Royal Randwick Racecourse
Proposed Hotel, Access, Parking and Bus Access Information

This letter has been prepared to address the issues highlighted by Department of Planning (DoP) and the Roads and Maritime Authority (RMS) in relation to the proposed Hotel development within the Royal Randwick Racecourse site. The ATC and PTC presented the proposal and the following responses to DoP and RMS on 8 November as a powerpoint presentation, which provided the opportunity for all present to discuss the proposal and ideas/comments that the design team could consider.

parkingandtrafficconsultants.com
wayfindingforum.com

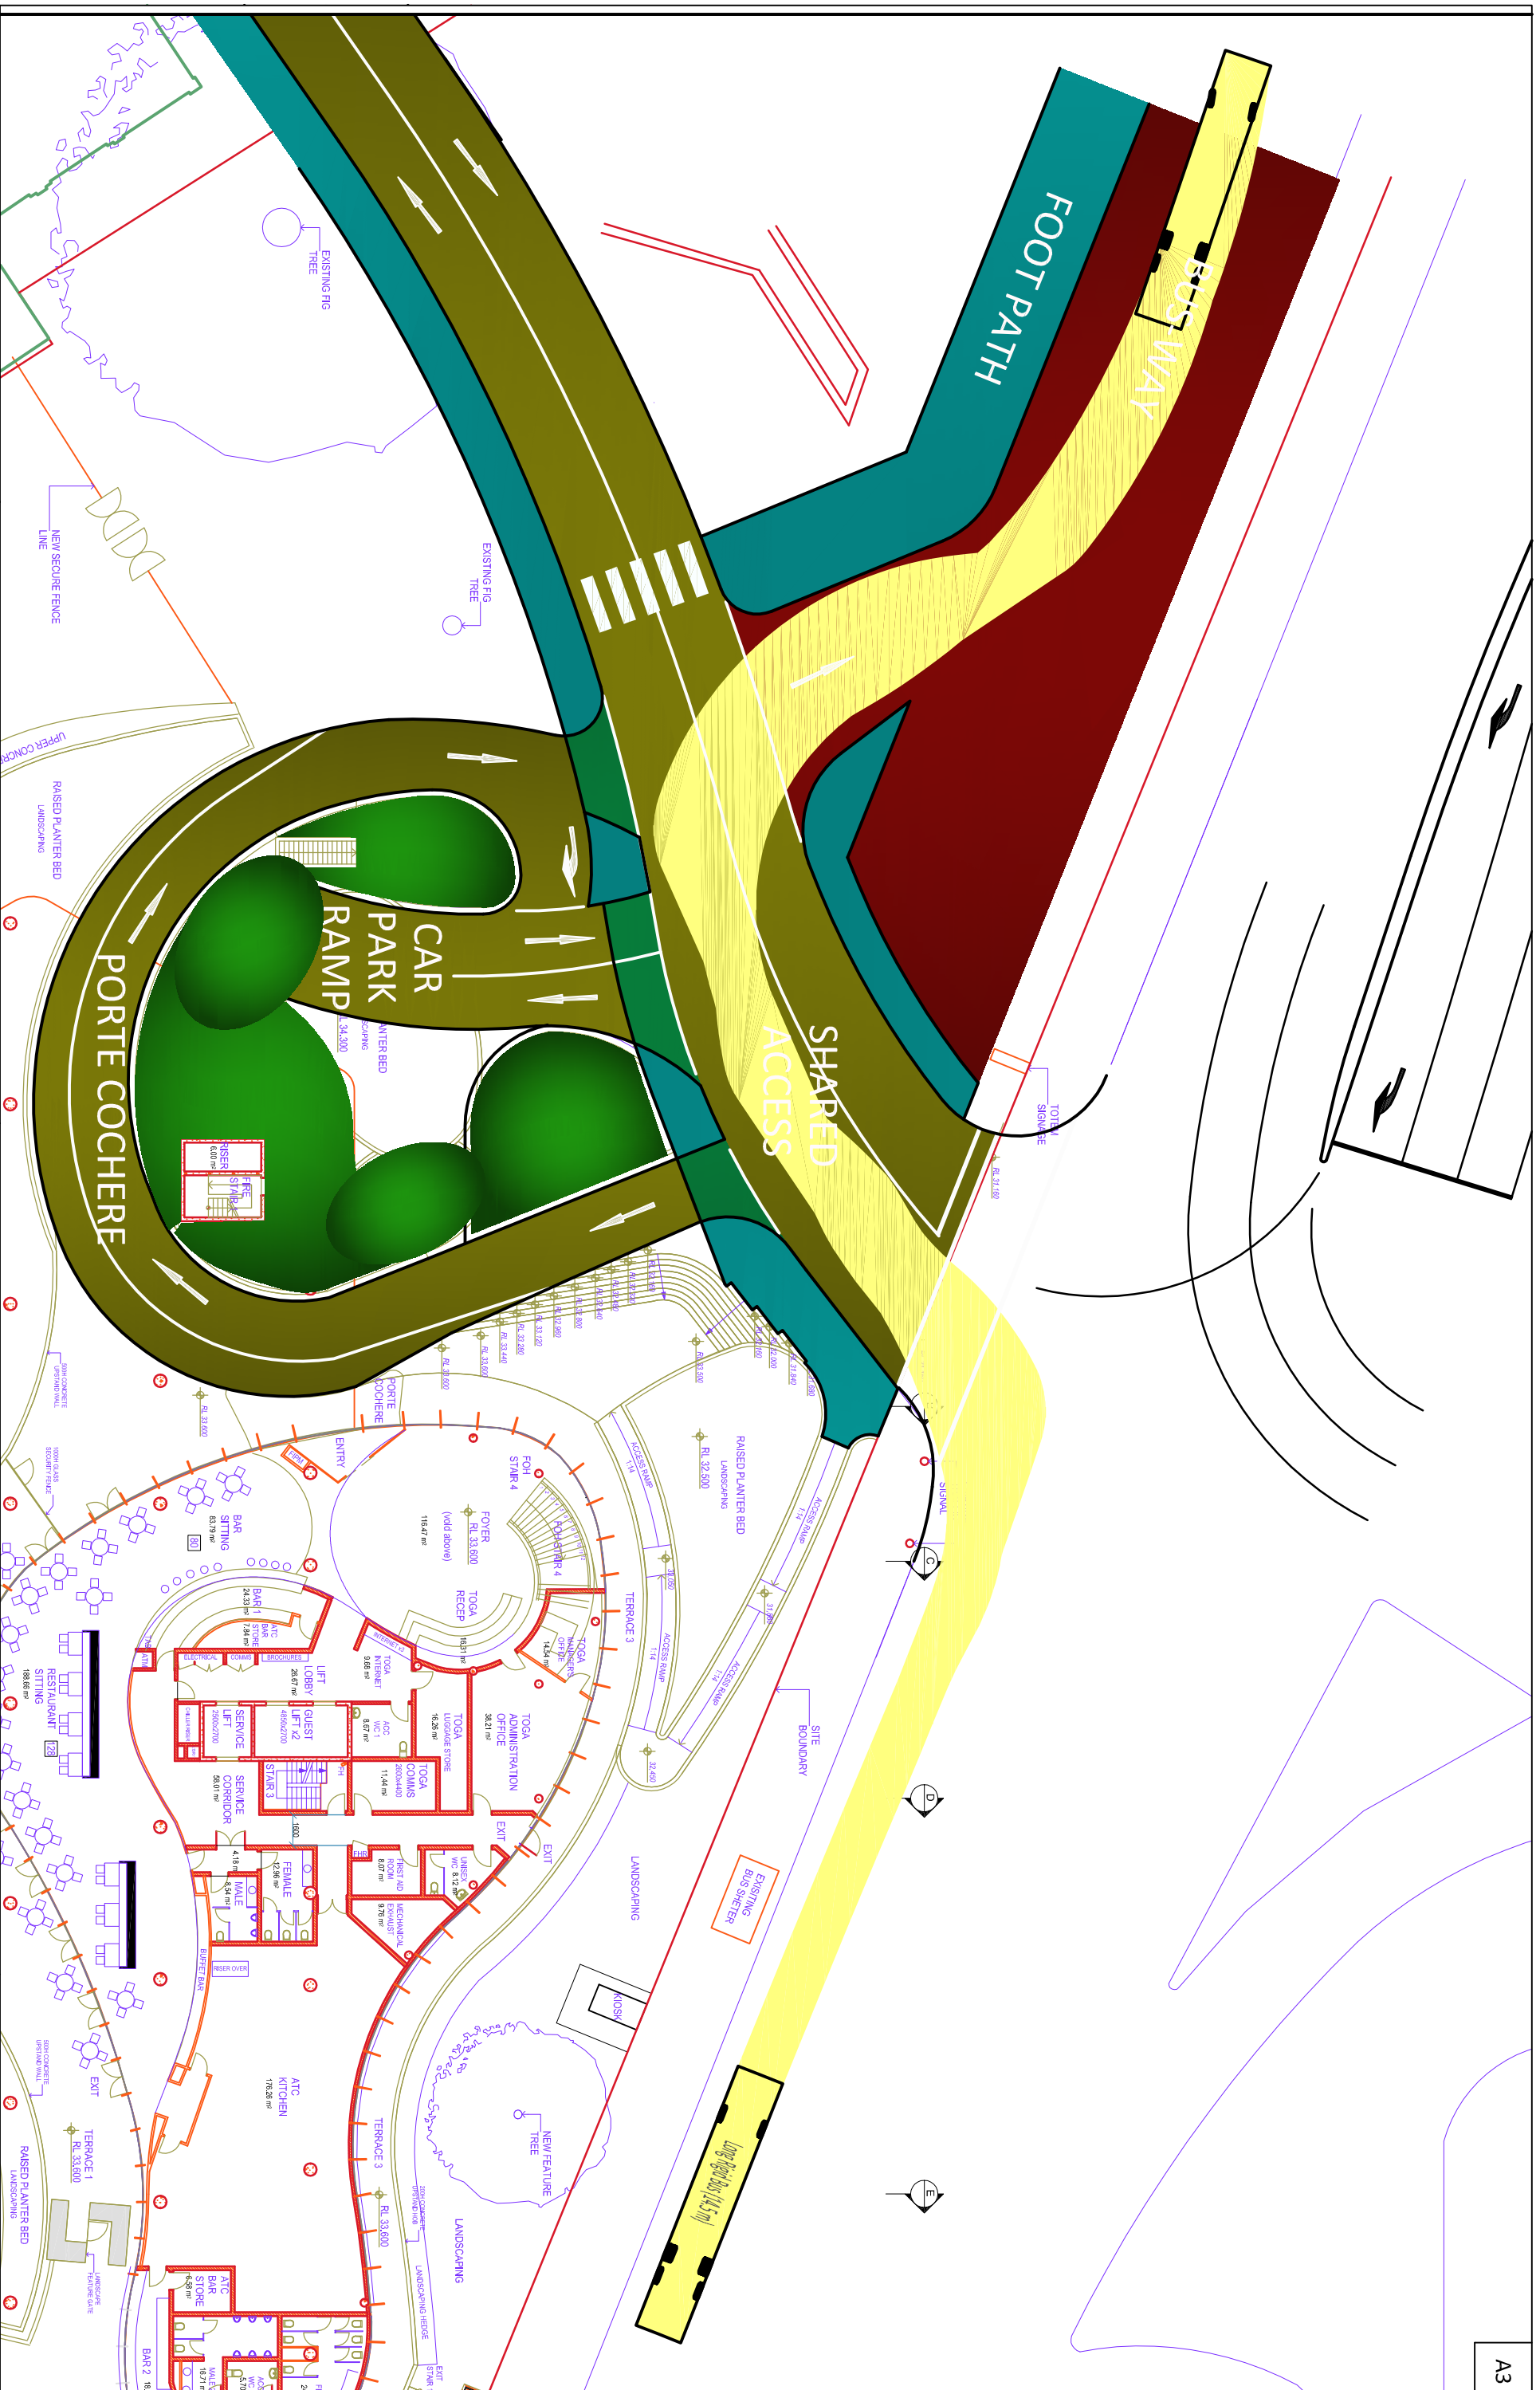
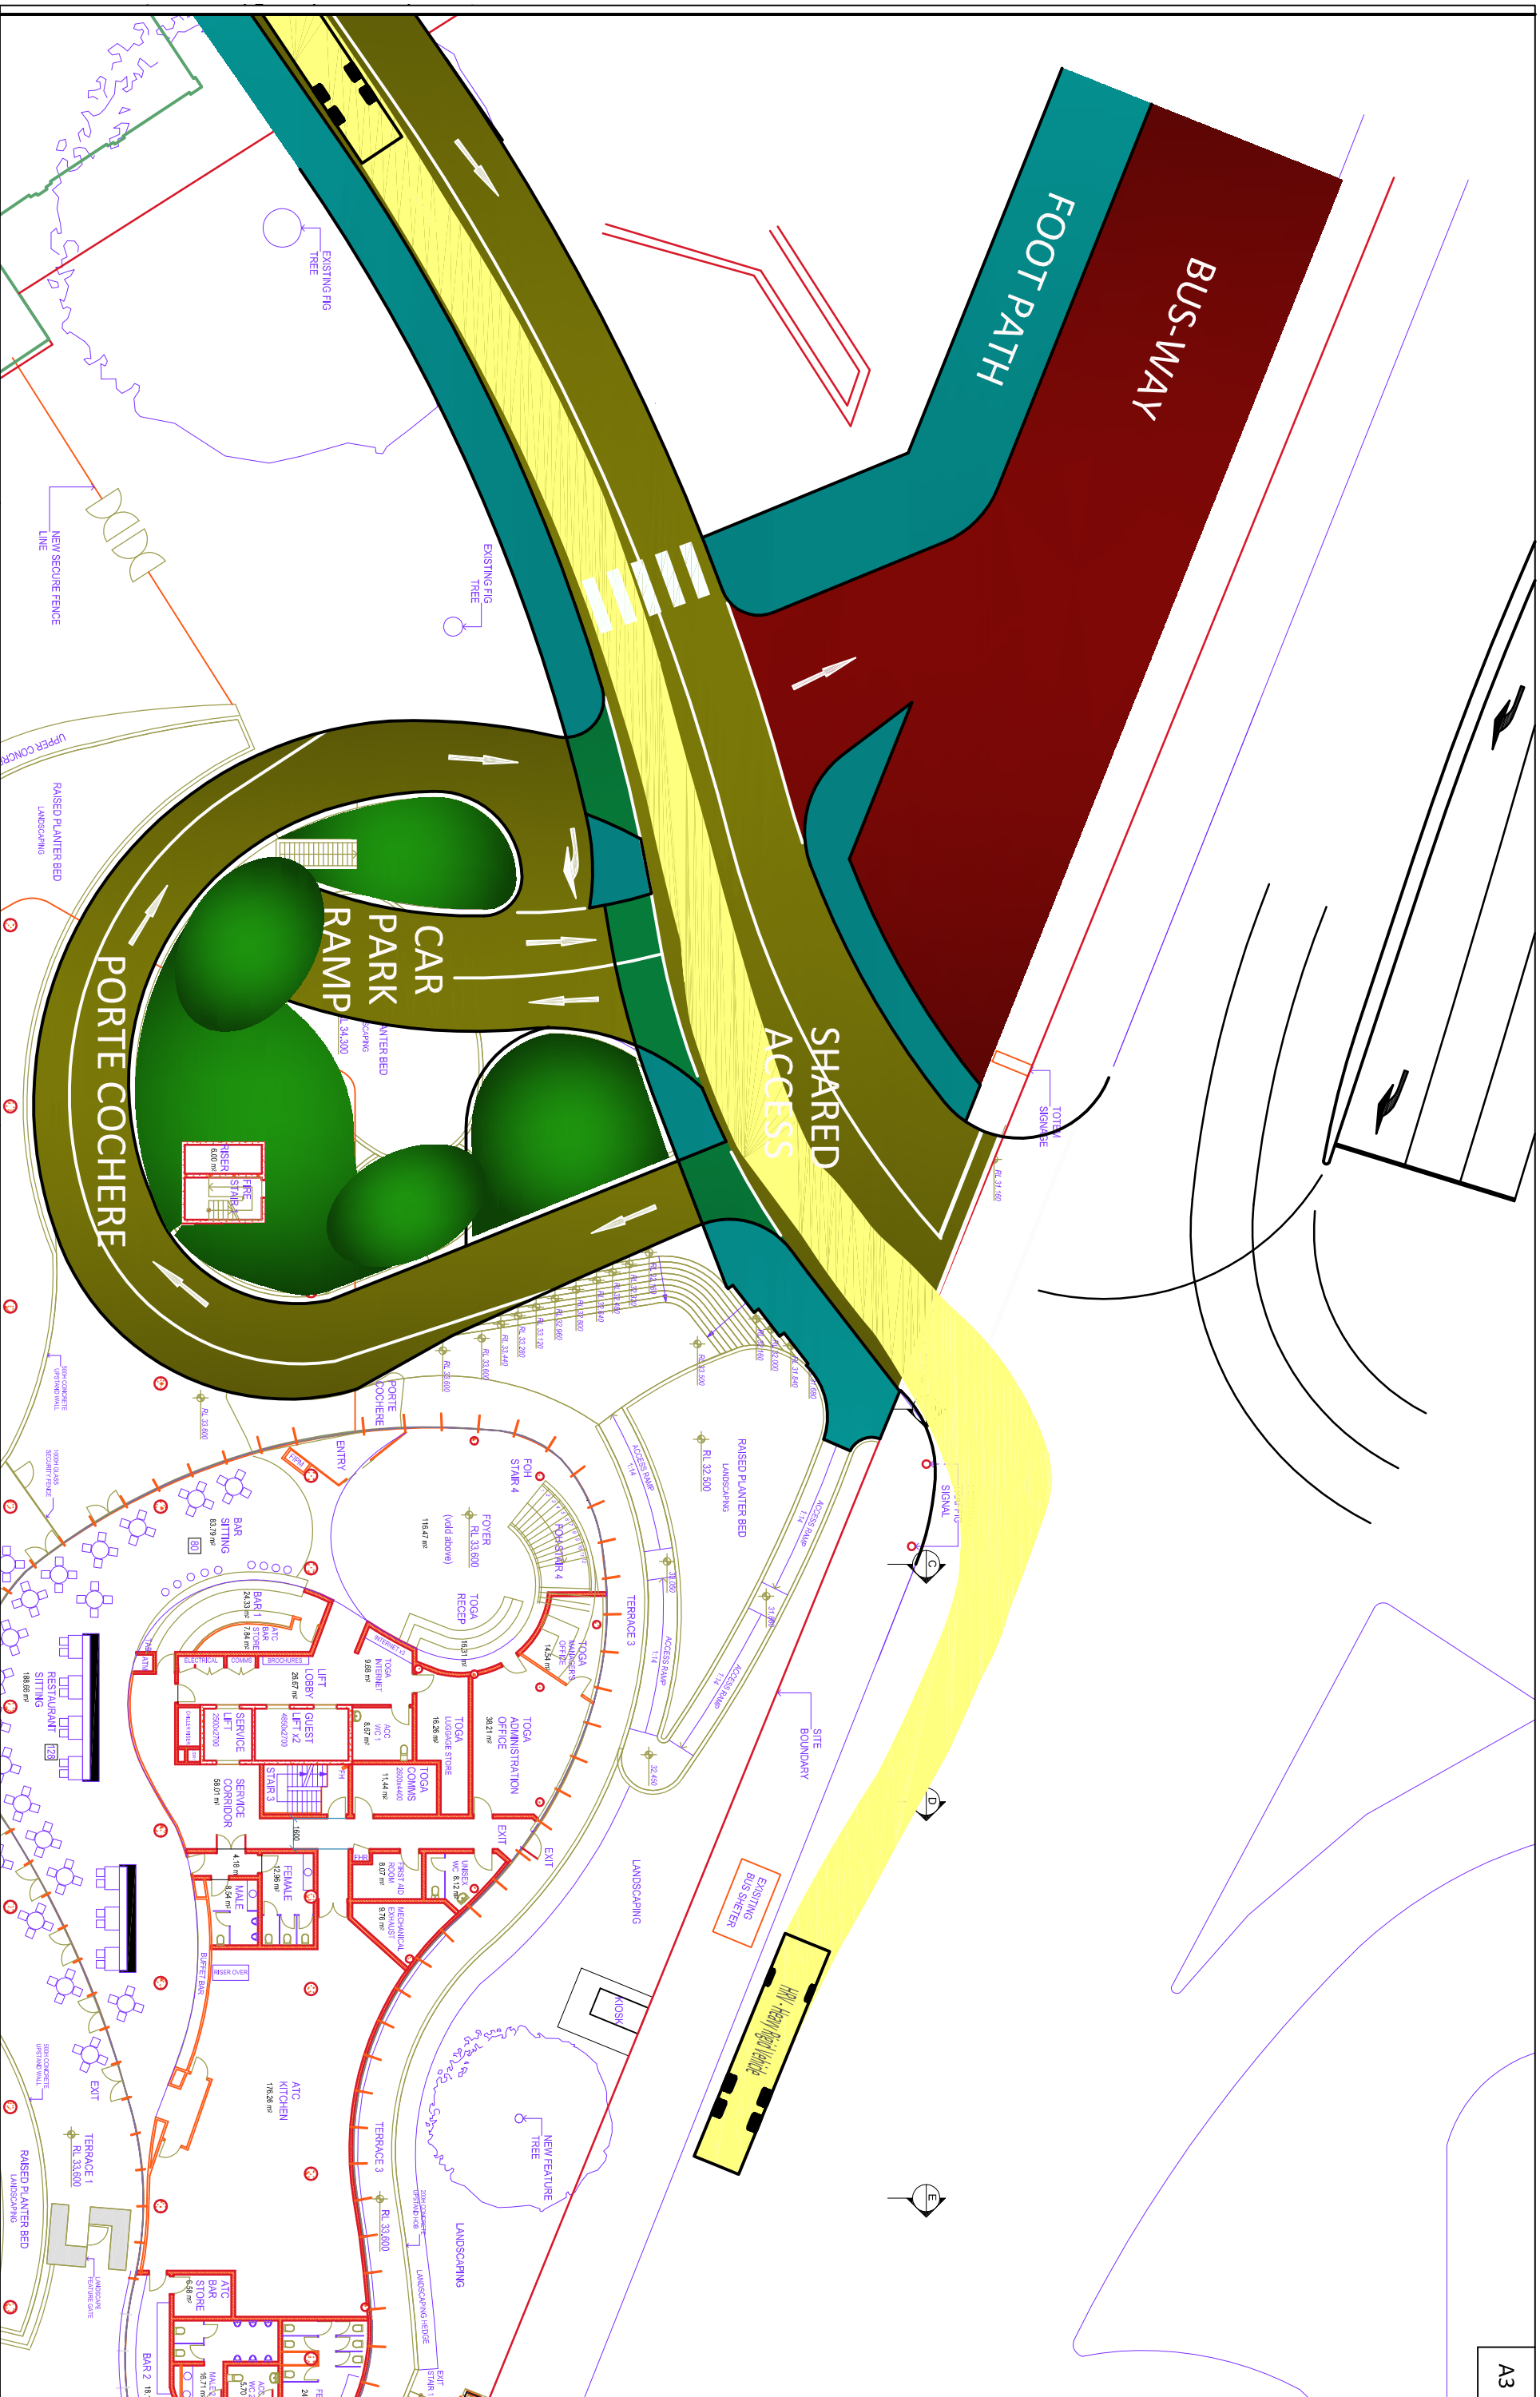
The proposed right turn into the site from Alison Road is not supported due to potential negative impacts on the surrounding road network and bus operations. An alternate arrangement should be considered to accommodate expected additional traffic without impacting on the existing road network. Any proposed alternate access arrangement should be supported by details of any SIDRA Modelling used, scaled plans illustrating adequate lane widths and vehicle turning circle into the site.

In conjunction with the traffic assessment submitted with the Development Application, a SIDRA analysis was prepared in order to determine the operation of the intersection before and after the hotel development. The modelling confirms that the 95th percentile queue for the site access right turn was 0.7 vehicles during the morning peak and 0.5 vehicles during the evening peak, indicating the proposed right turn lane length of 25 metres (excluding taper). The length of the right turn lane is sufficient to accommodate the queuing expected during normal operation, but will accommodate two 12.5 metre long

buses when in use in relation to the bus-way. We have prepared microsimulation modelling, which demonstrates that no more than two buses arrived at one time over the period of the modelling. This was based on the peak bus volume (26 buses in 1 hour) superimposed over the peak traffic volumes associated with the Epsom Super Saturday. To provide a sensitivity test, we then doubled the number of buses, which indicates that up 58 buses per hour can arrive via the intersection with no more than 2 buses being queued. The management of bus arrivals is also an important aspect of the proposed arrangement, which is discussed in detail further below.

Swept paths are shown as **Attachment A**, demonstrating that all movements can be undertaken by the appropriate vehicles, including the right turn from Darley Road by a bus in the outside lane, along with two cars in the inside lanes.
